M54 to M6 Link Road
TR010054

8.28 Applicant Responses to Deadline 7
Representations and Examining
Authority Requests

**Applicant Responses to Deadline 7 Representations and Examining
Authority Requests**

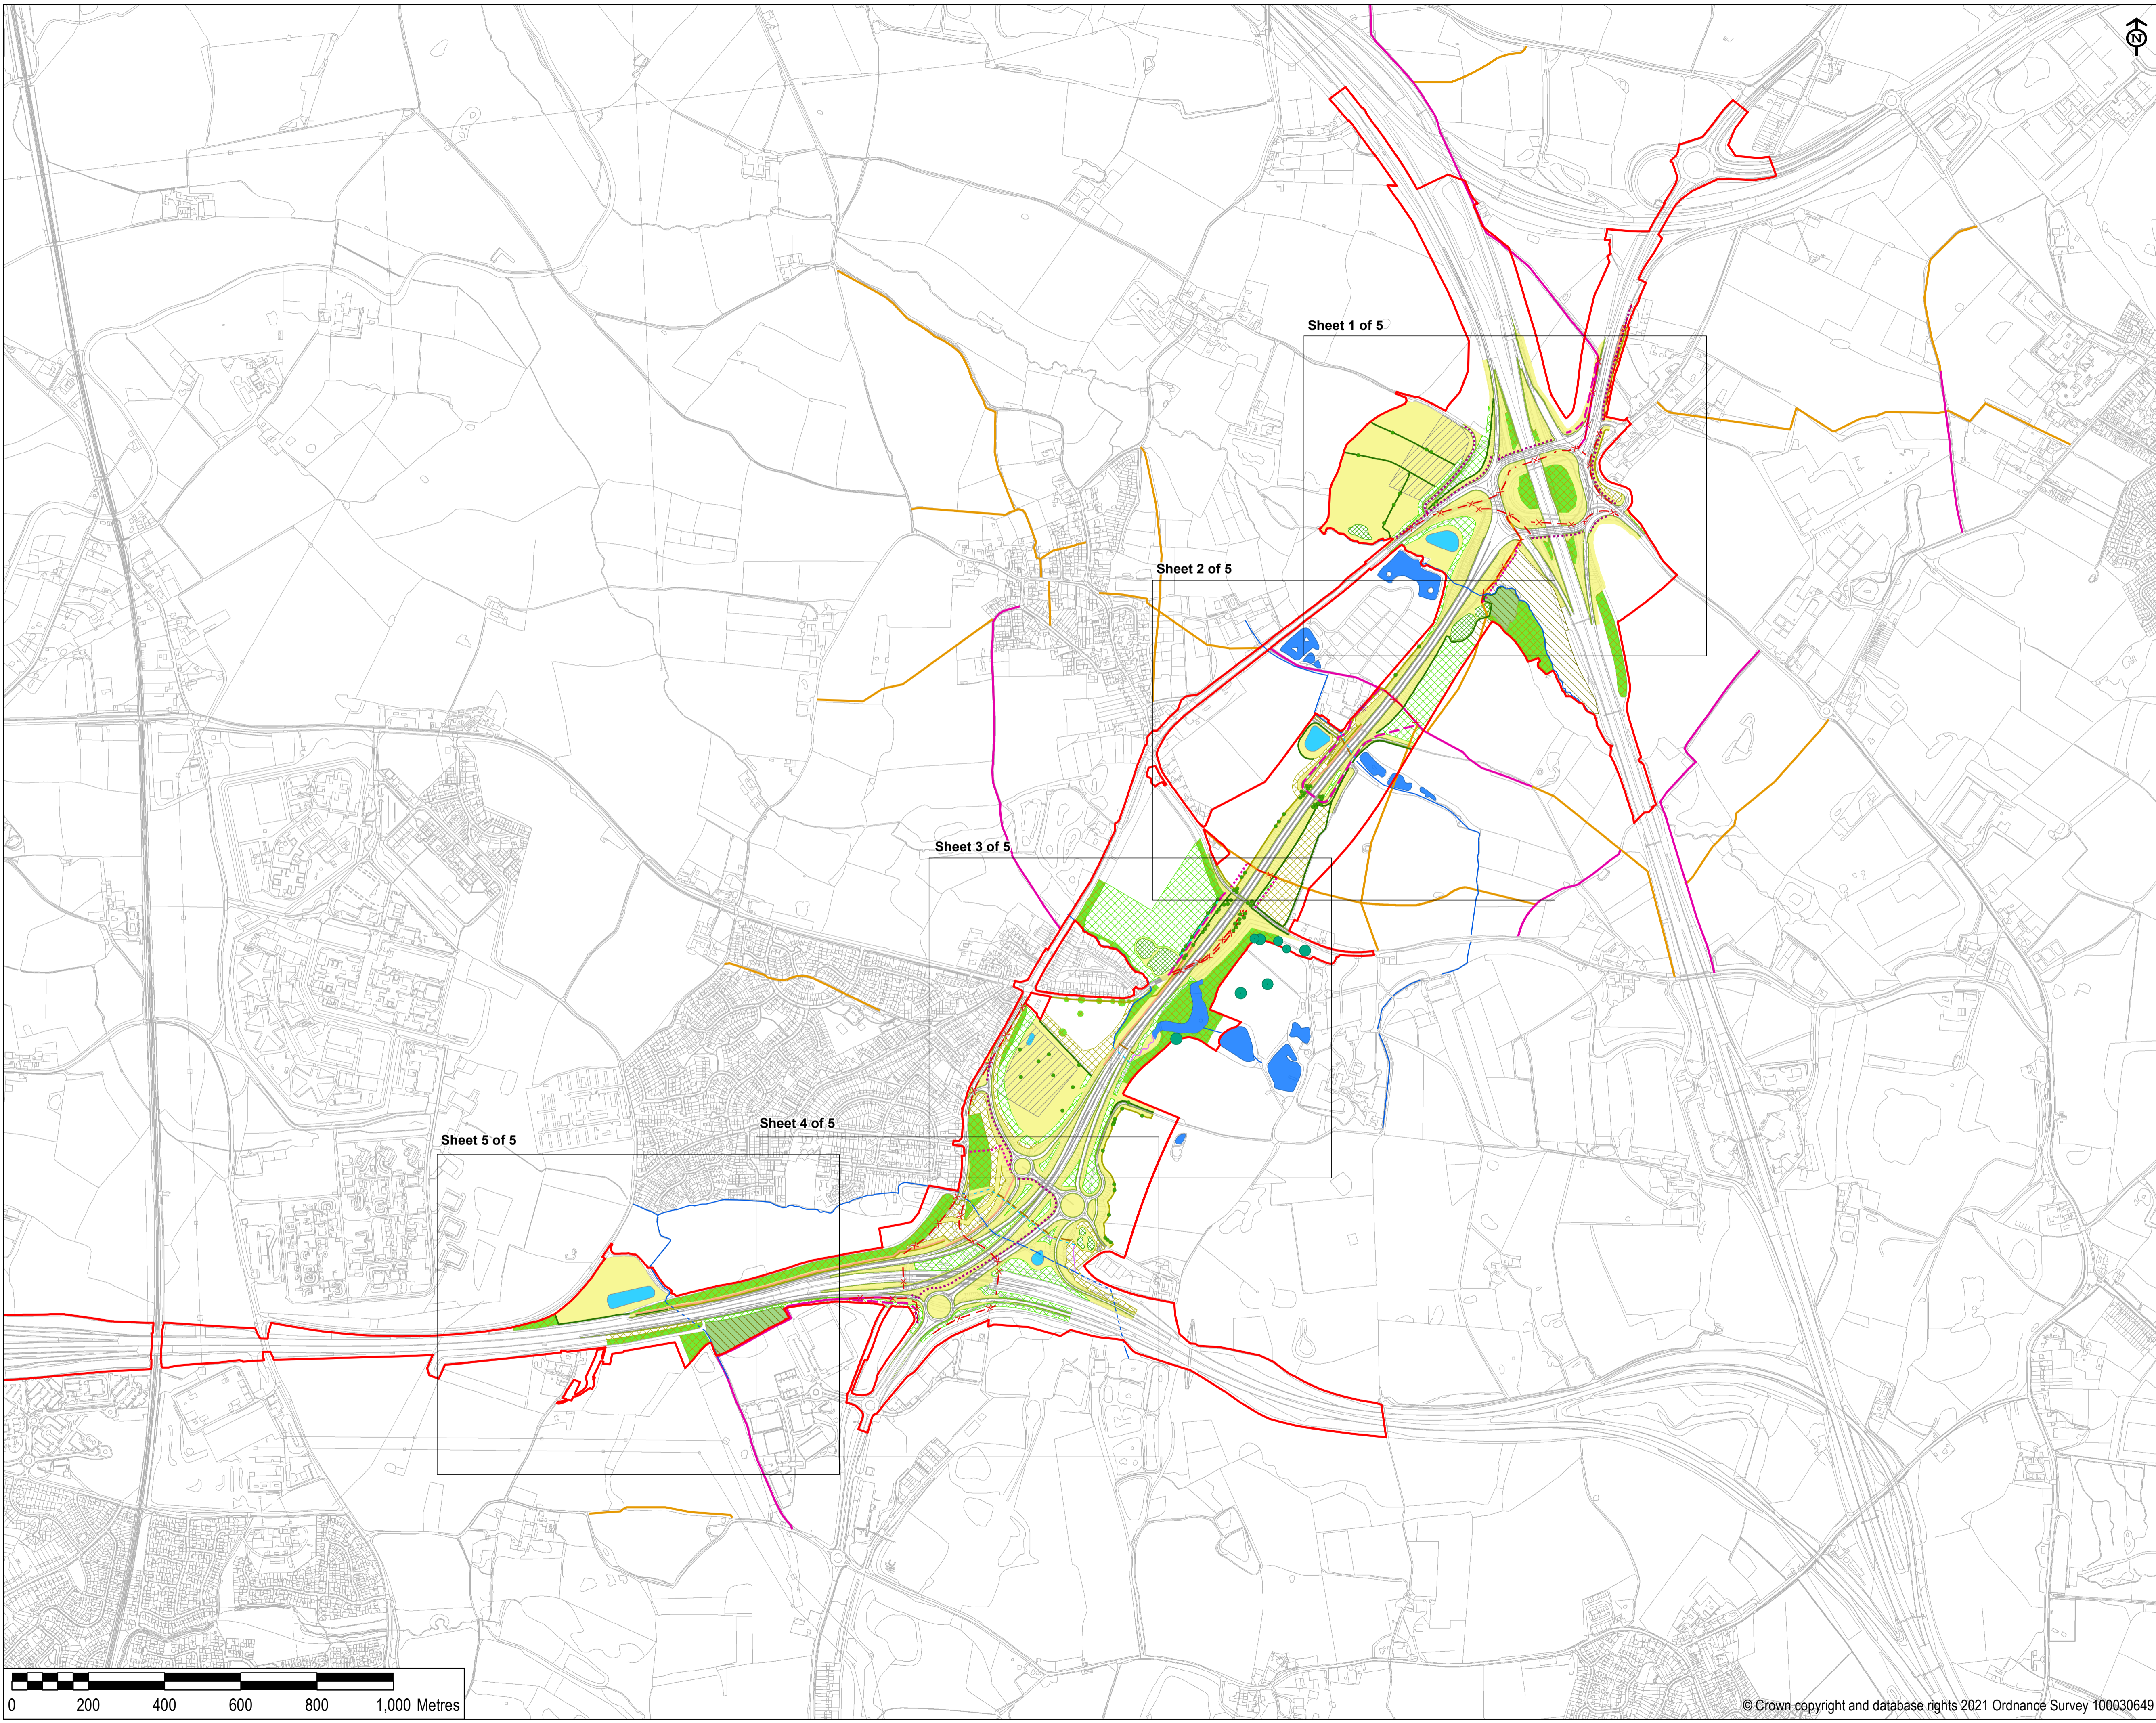
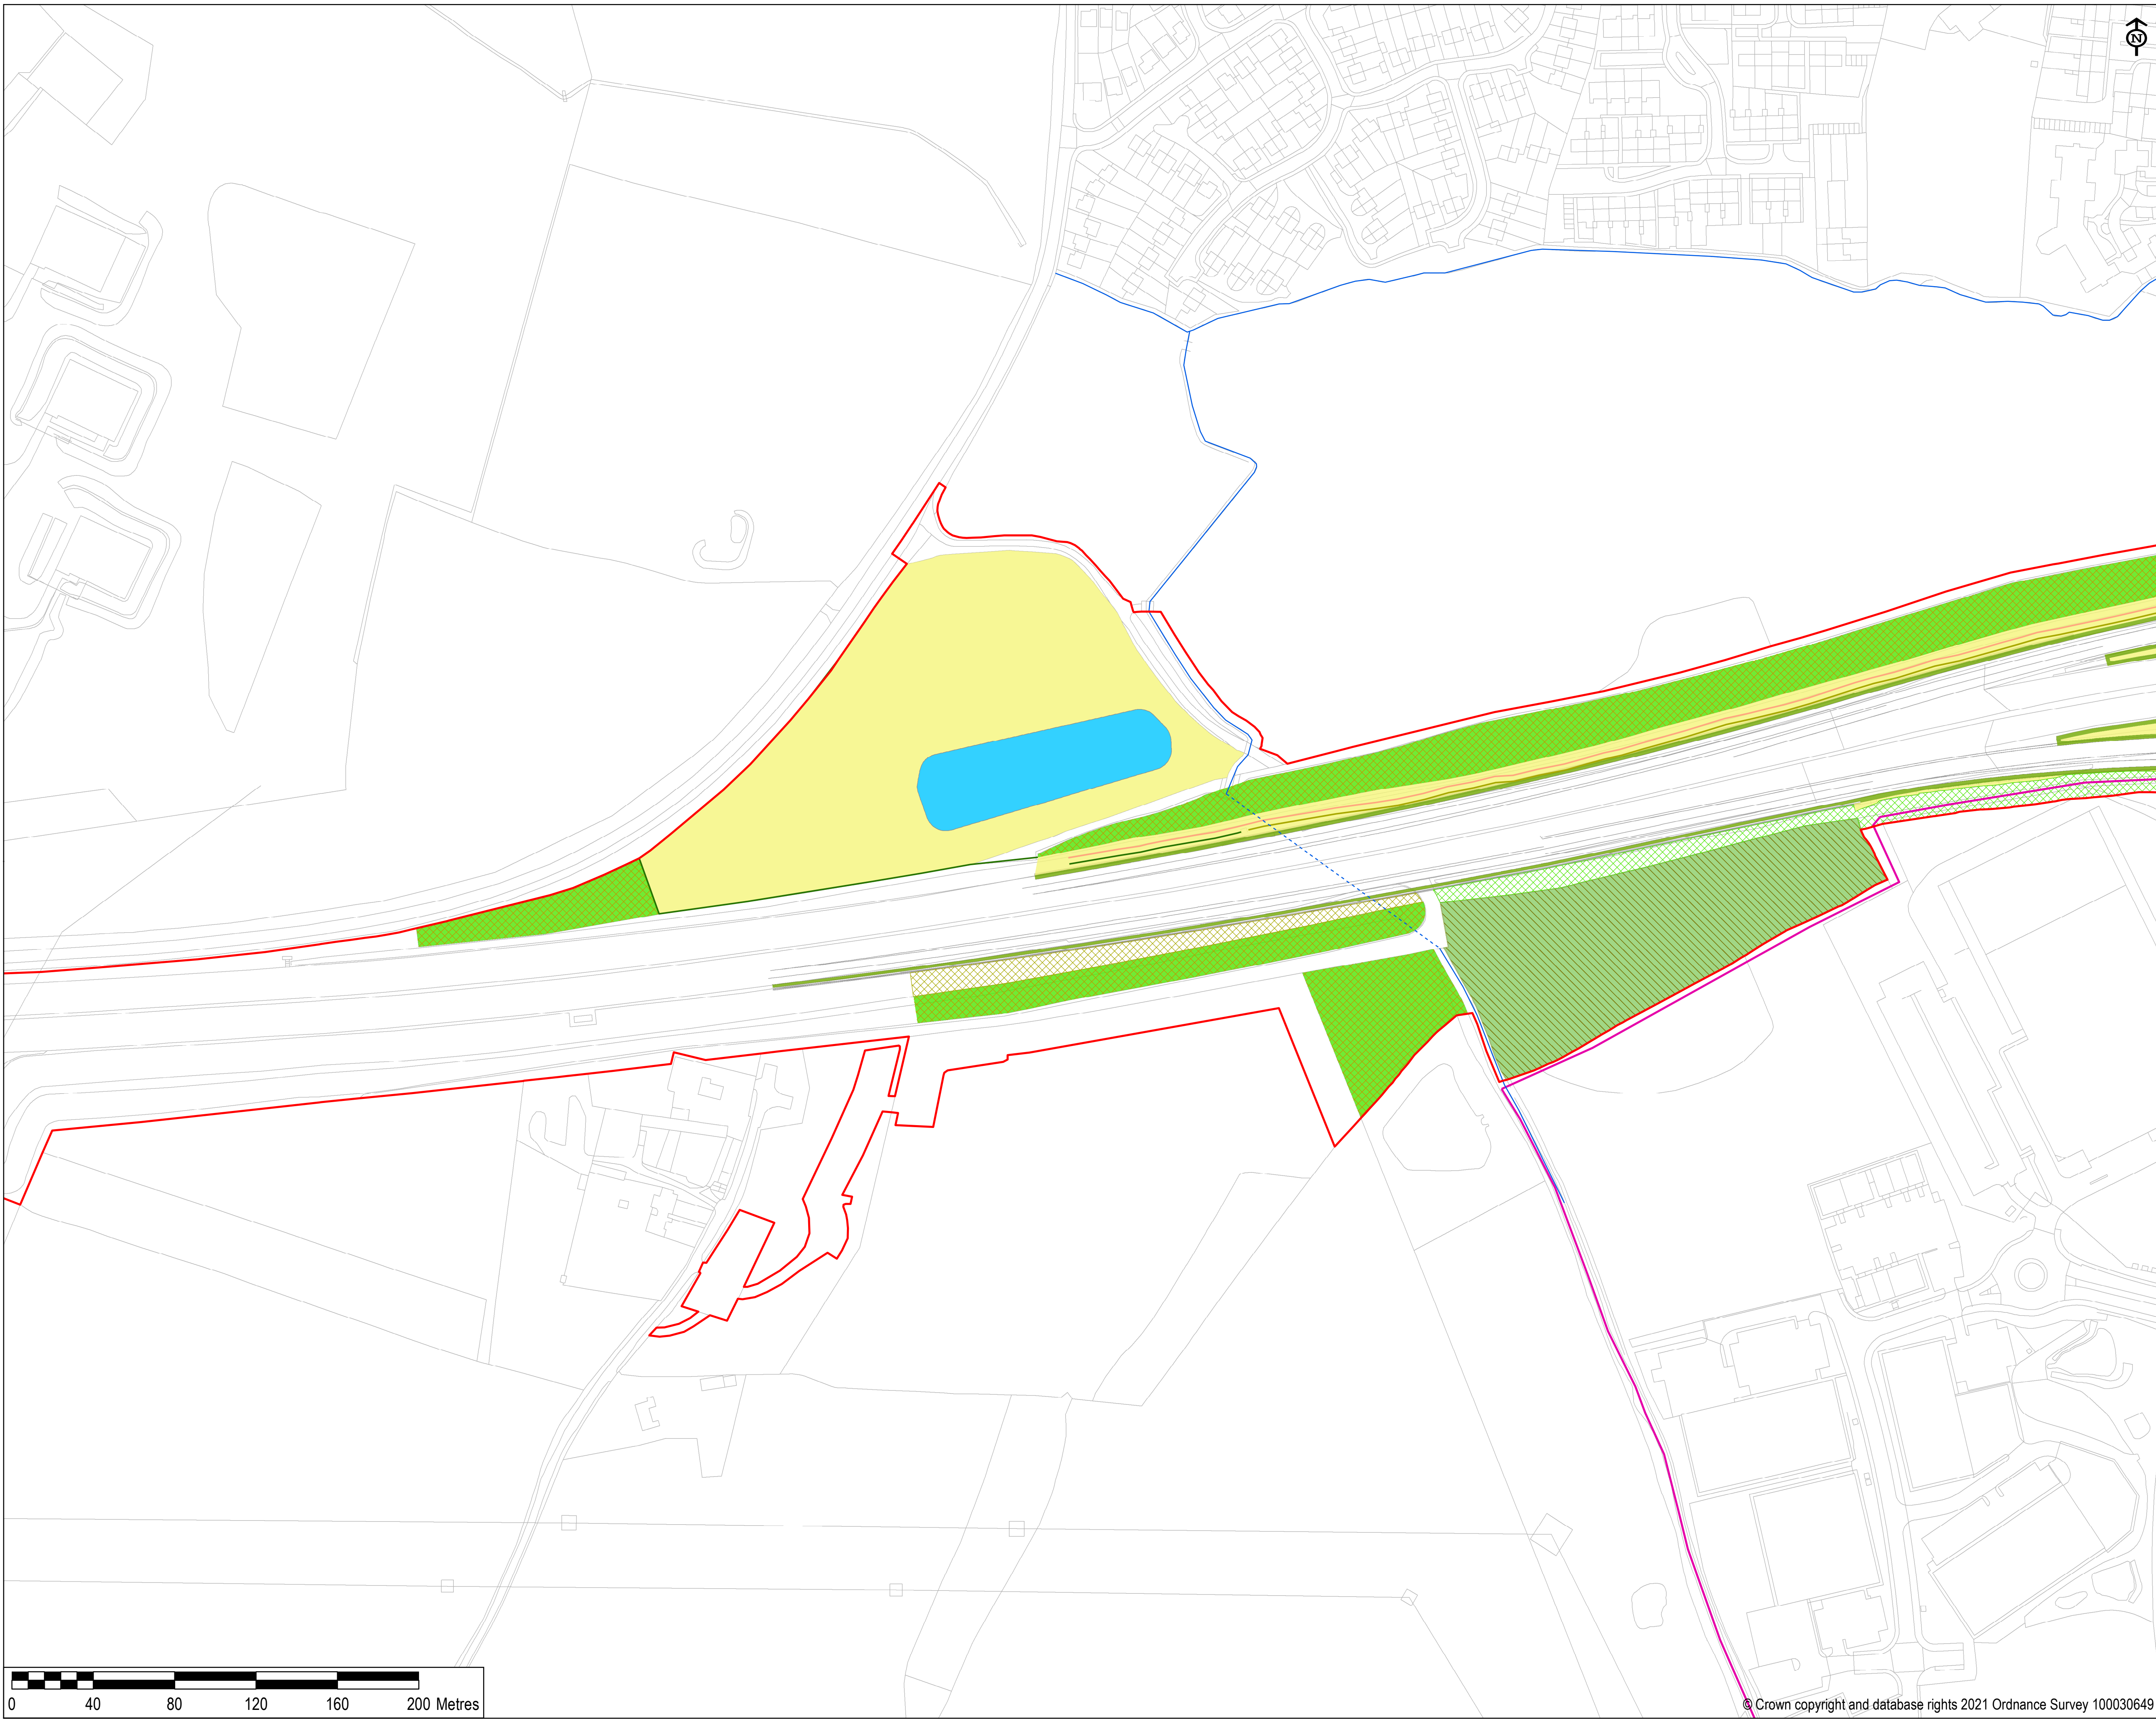
Representor	Topic	Ref	Representation	Applicant's Response
			<p>The area shown on the revised environmental masterplan shows the area of 5/2 as approximately 6.1 ha which is well in excess of the 5.41 ha or thereabouts, (4.84 + 0.57), that would be anticipated from the Applicants calculations. Please can the applicant clarify the areas shown on their masterplan?</p> <p>An additional area of 0.96 ha is also being acquired within 4/20c which has been described as both required for landscape purposes as well as forming part of a network of environmental mitigation habitats, including a potential bat crossing point (although this is not agreed as a suitable and safe crossing point by Allow's environmental consultant). They have however also stated that this is not calculated to offset the Lower Pool losses.</p> <p>At 3.7.3 the Applicant has not considered it appropriate to reduce the area required for landscape impact mitigation at 4/20c. The Applicant has however accepted that their methodology and assessment of impact buffers in this area was inappropriate and excessive.</p> <p>The area of land to be taken for woodland mitigation in total from Allow therefore amounts on the masterplan in total to over 7 ha, being well in excess of the ratio of approximately 2:1 for SBI mitigation, and a lesser ratio for non-SBI mitigation stated by the Applicant. Once again, we appeal to the judgement of the Examining Authority to question the evidence and appropriate application of the Applicant's figures in assessing appropriate and justified land acquisition for woodland planting.</p>
